# Norfolk Boreas Offshore Wind Farm Applicant's Comments on Deadline 8 Submissions

Applicant: Norfolk Boreas Limited  
Document Reference: ExA.ASR.D9.V1  
Deadline 9

Date: April 2020  
Revision: Version 1  
Author: Royal HaskoningDHV

Plate 5 Substation Search Area Sectors and Constraints

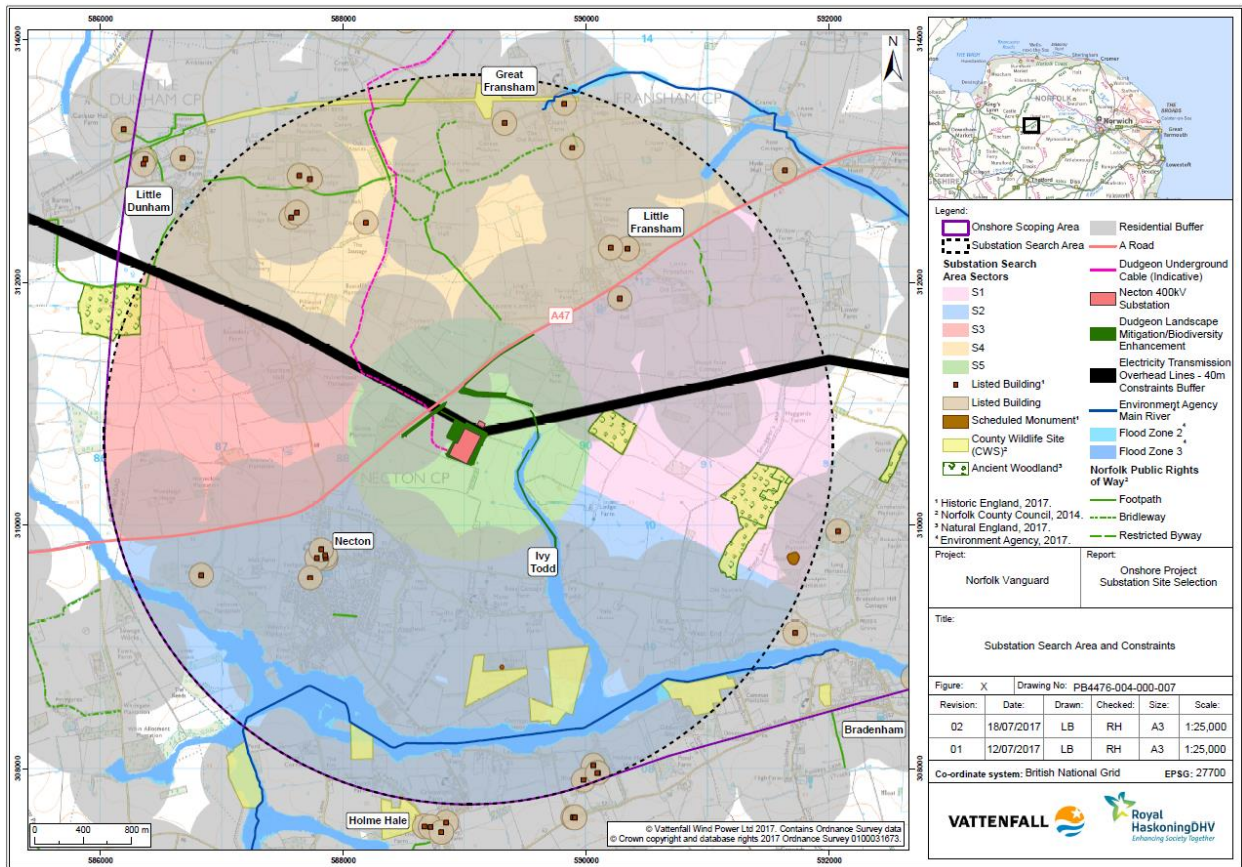
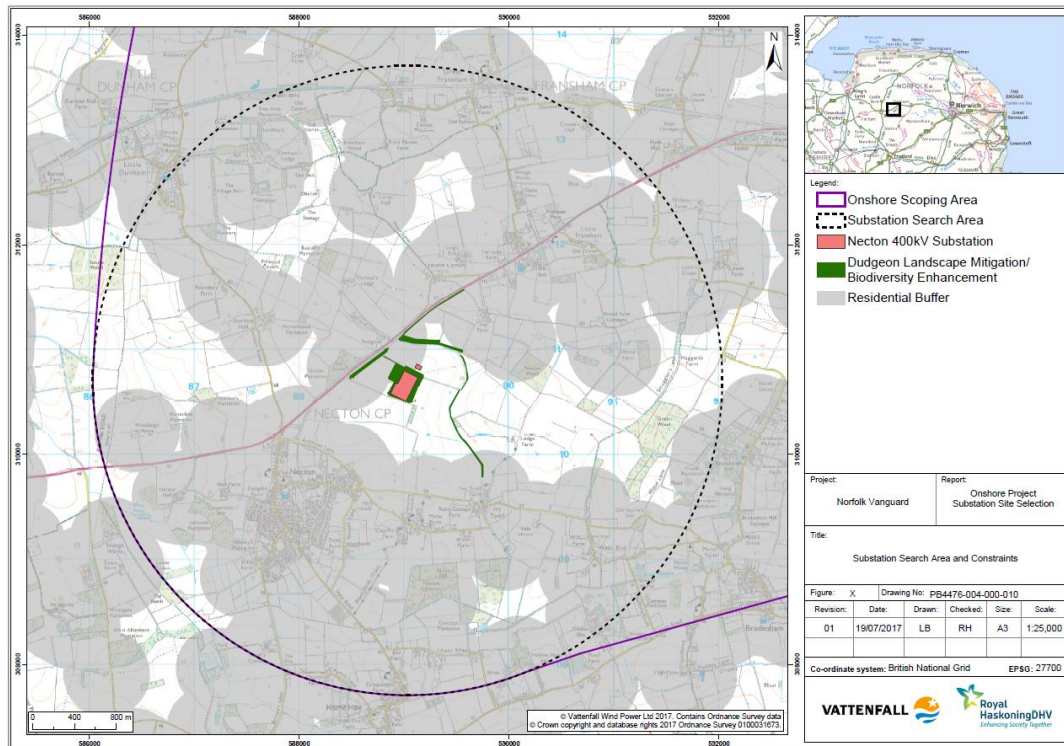
Summary of Submission	Applicant's Comments
	<p><i>wish to acquire over land for the cable requirements, rather than a value to acquire existing easements which need to be stopped up."</i></p>
<p>REP8-035 suggests that the project is going to encroach on Ivy Todd's and West End's residential buffer zone.</p>	<p>During the site selection process, a buffer was applied to all residential properties within the onshore project substation search area to identify an area with increased separation distances (see ES Appendix 4.10 [APP-546].</p> <p>The residential buffer zone is shown on ES Figure 4.10 [APP-257] and includes properties at Ivy Todd and West End. ES Figure 4.10 [APP-257] shows that the onshore project substation site is outside these and all the residential buffer zones.</p>

**APPENDIX 3: OS MAP SHOWING CHANGE IN LEVELS VP3 (AGENDA ITEM
4 (a) II)**

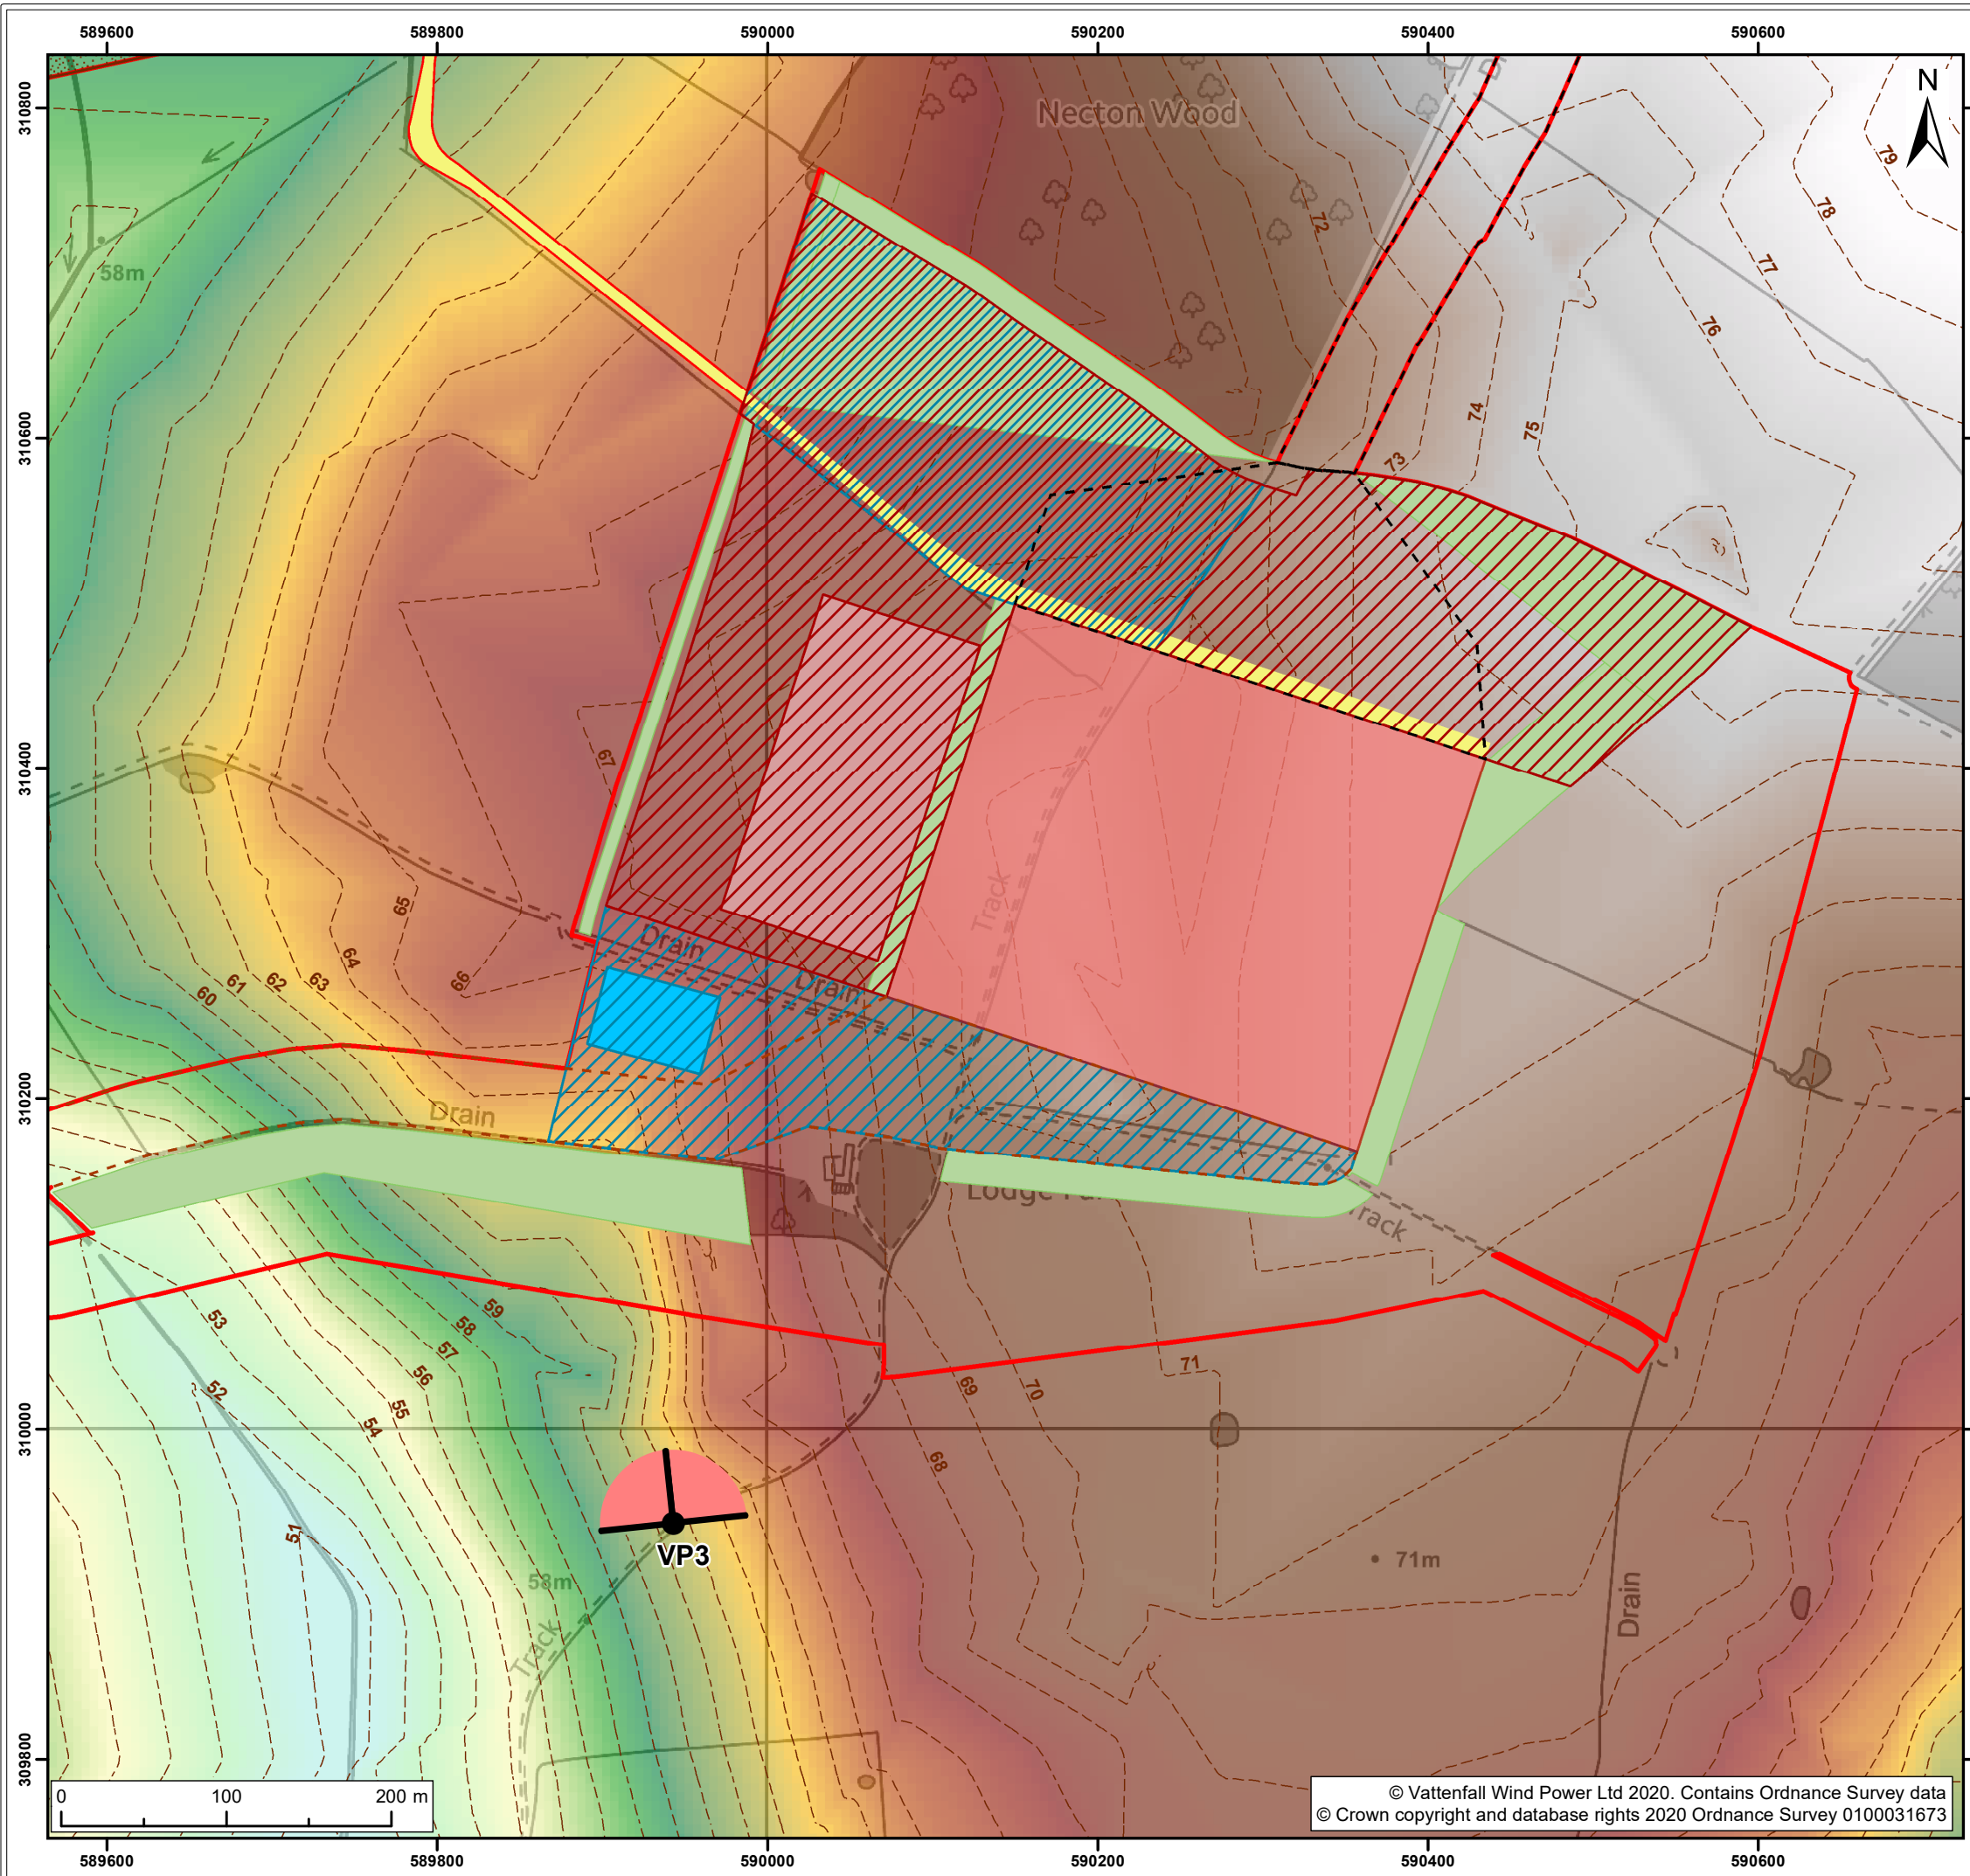
Summary of Submission	Applicant's Comments
	<p>Therefore, no change to the 'noise limit radius' is considered necessary to accommodate land which is used for agricultural purposes.</p> <p>The operational noise limits, as secured by dDCO Requirement 27, are cumulative with the existing onshore infrastructure to ensure the soundscape at the identified and agreed receptors does not change beyond the existing Dudgeon condition noise levels from the operation of the Norfolk Boreas and / or Norfolk Vanguard onshore project substation.</p>
<p>REP8-035 acknowledges the updated cross sections however comments they show different visibility to the Applicant's visualisations at Viewpoints 3 and 7.</p>	<p>The screening seen in the visualisations of Viewpoint 3 and 7 relates partly to landform and partly to existing tree cover. In respect of Viewpoint 3, the mature trees around Lodge Farm (approximately 18m tall) reduce the extent to which the onshore project substation would be visible. An updated cross section of Viewpoint 3 showing this existing woodland is presented in Appendix 1. Similarly, from Viewpoint 7, there is tree cover along an intermediate field boundary which, owing to its closer proximity to the viewpoint, is of a comparable scale to the scale of the onshore project substation. While the Rochdale envelope is set at 25m to include the lightning masts, the building is set at a maximum height of 19m which may account for less being visible in the visualisations than might be anticipated.</p>
